About the application

Application number: 2023/90346	
What is the application for?:	Erection of two detached dwellings
Address of the site or building:	land at, Greenhill Bank Road, New Mill, Holmfirth, HD9 1ER
Postcode:

User comments

Elevations

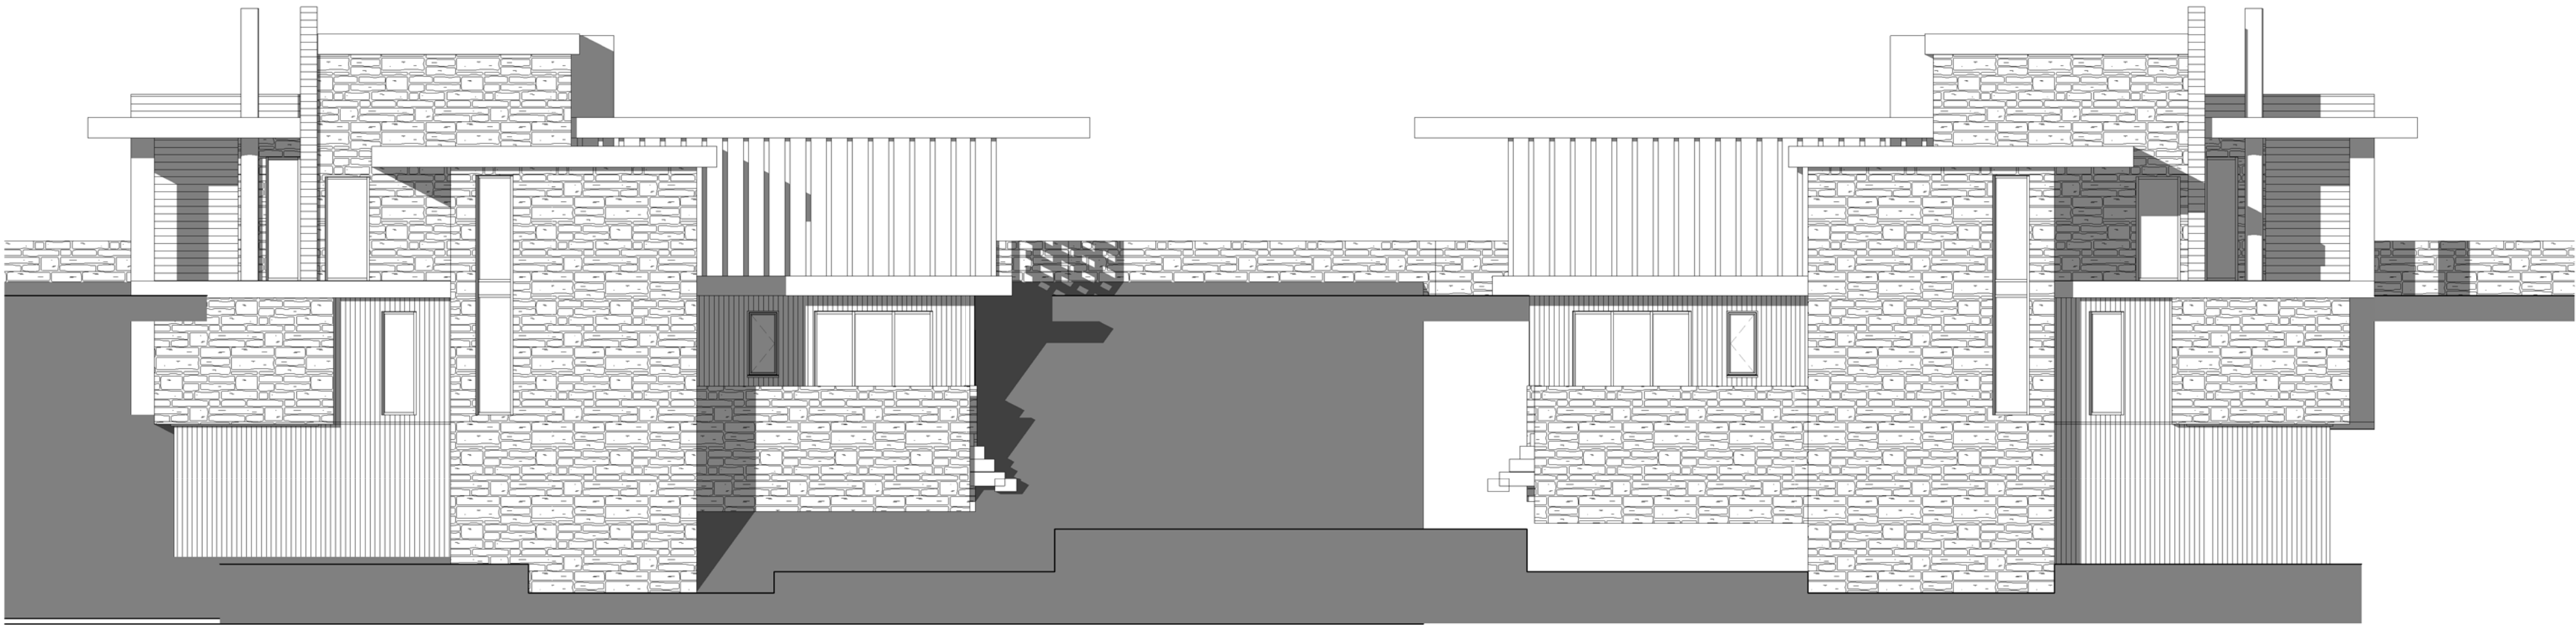
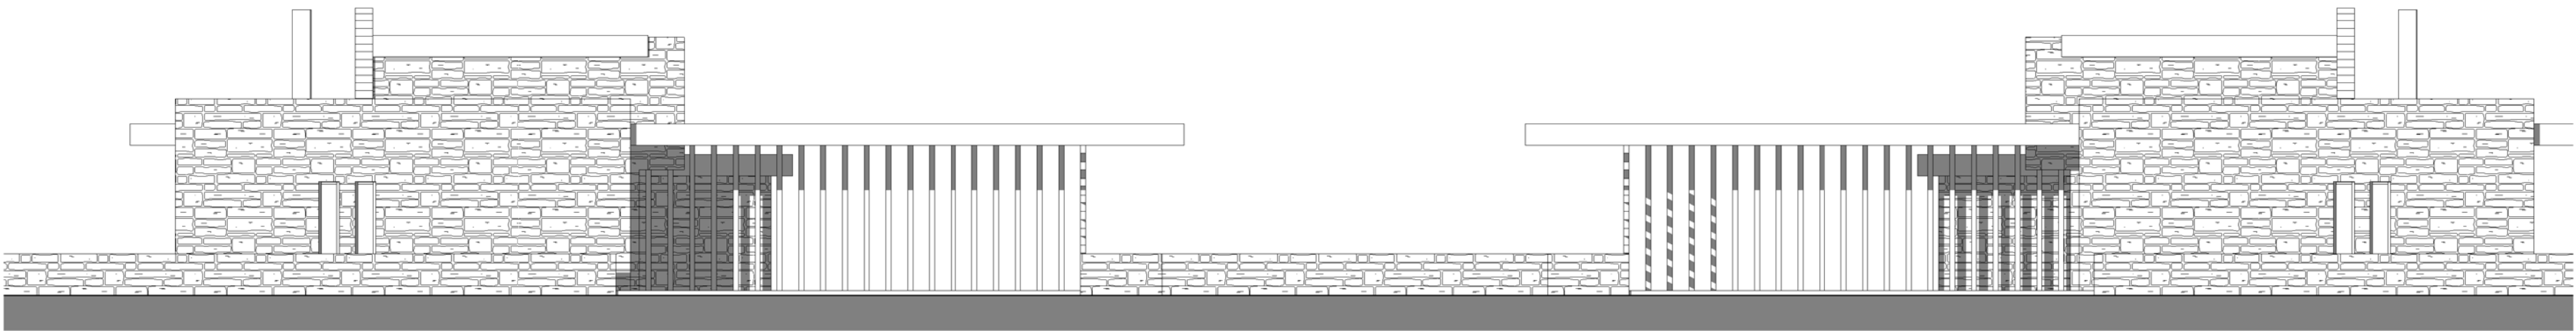
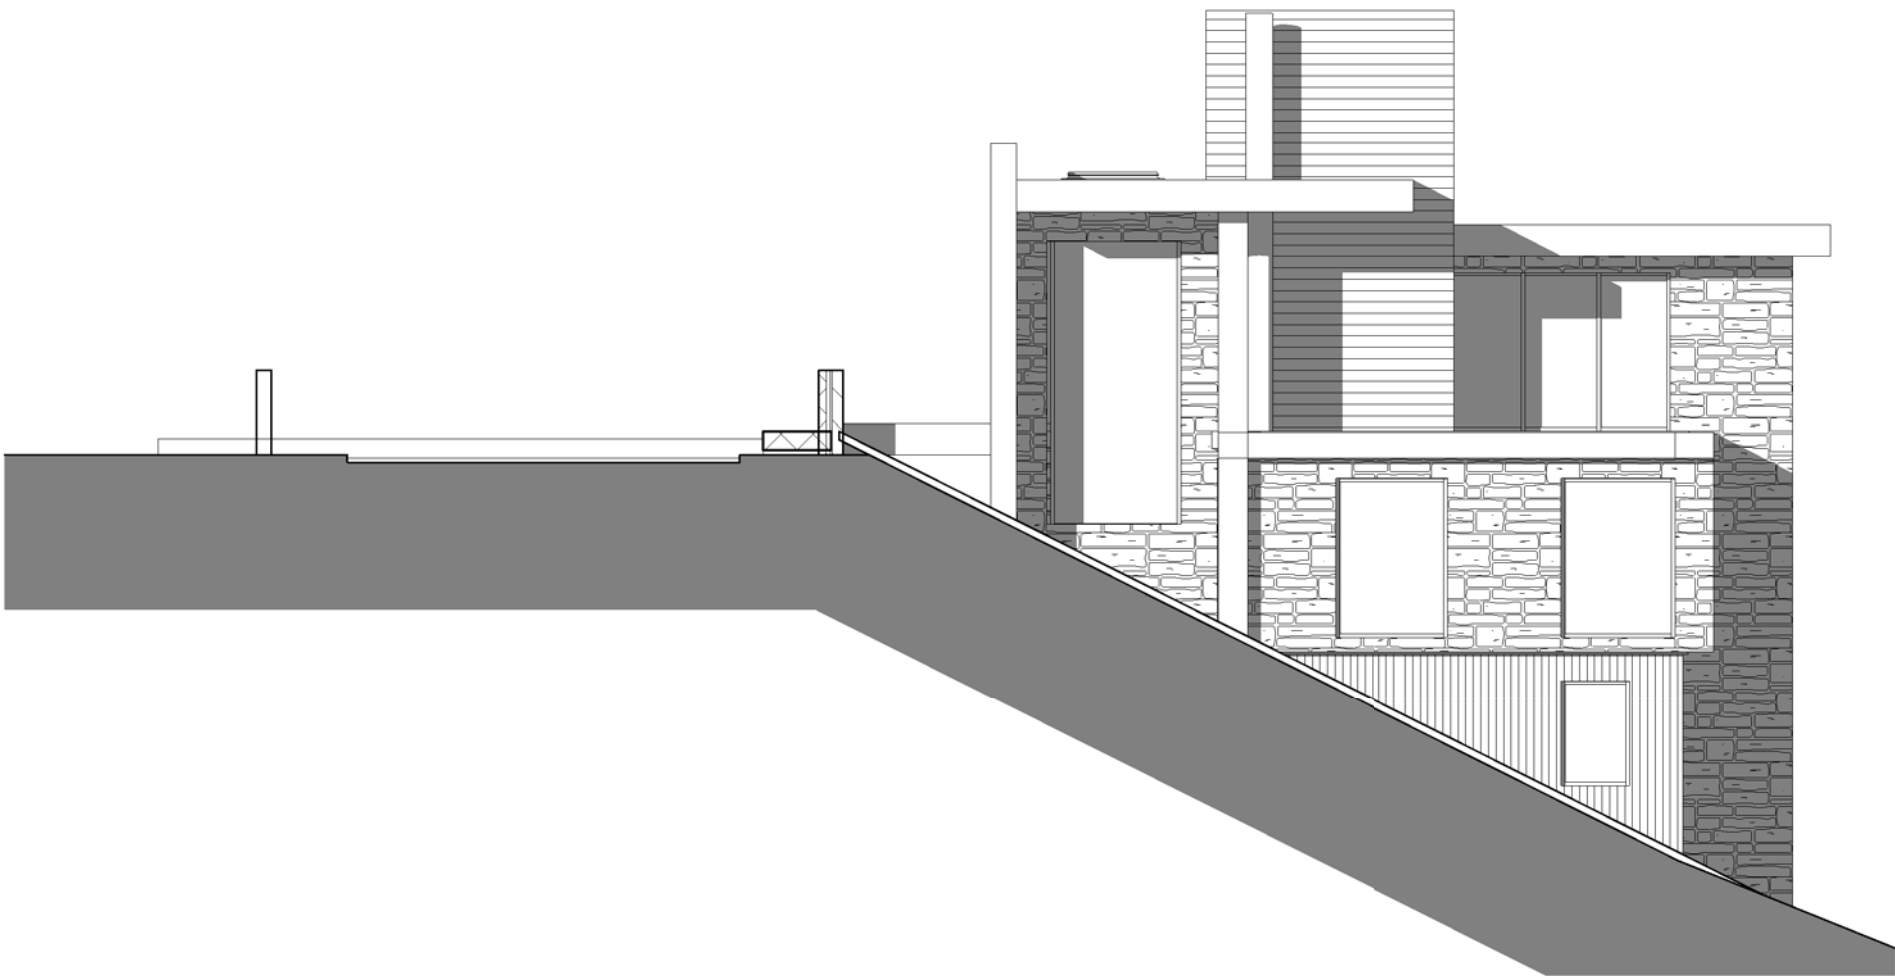
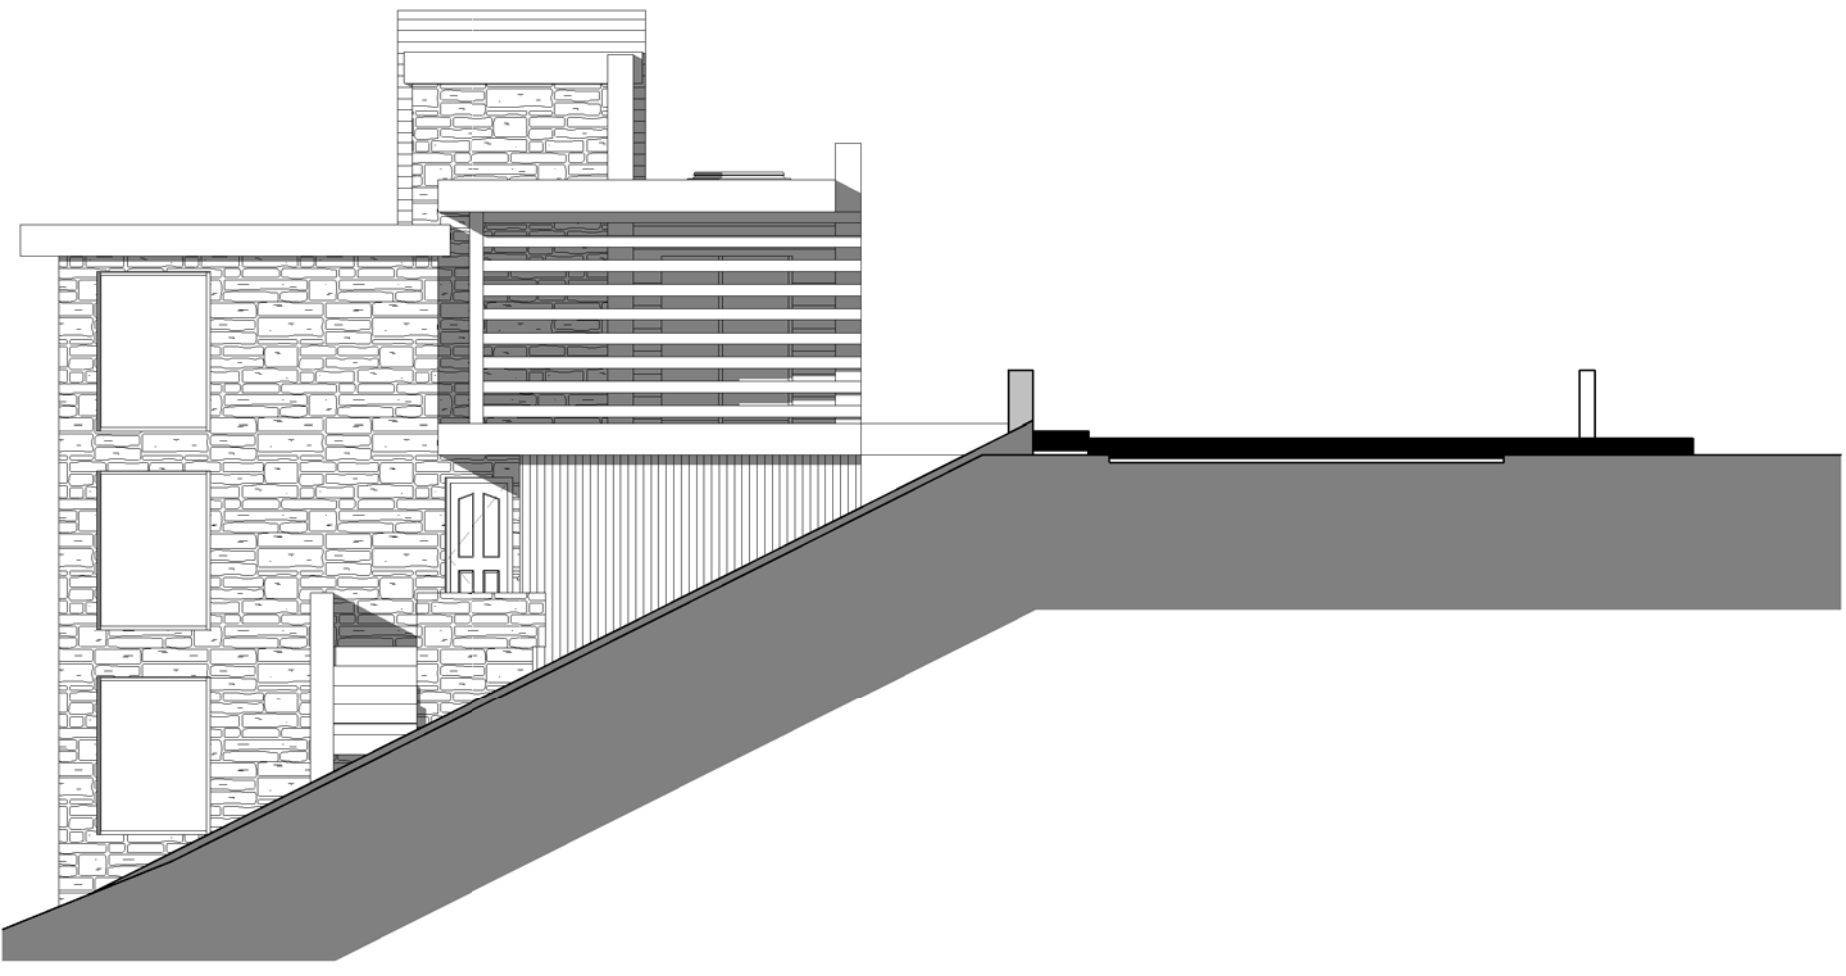
Type of comment: An objection	
Do you wish your comments to be published on the website anonymously?	Yes
How do local people get to know about new building applications when nothing has been posted on lampposts in the vicinity. There is nothing about this application on Greenhill Bank. The design of these 2 properties is not in keeping with the surrounding properties. This is quite a narrow road - only wide enough for 2 cars. There will be disruption to traffic during the build as it is a main route to Scholes and Totties and there is no space for vehicles to be parked off road. The surface of the road, at the point of this development, is already showing signs of cracking since being resurfaced a few years ago so any further disturbance could possibly cause yet another Holme Valley road to collapse.
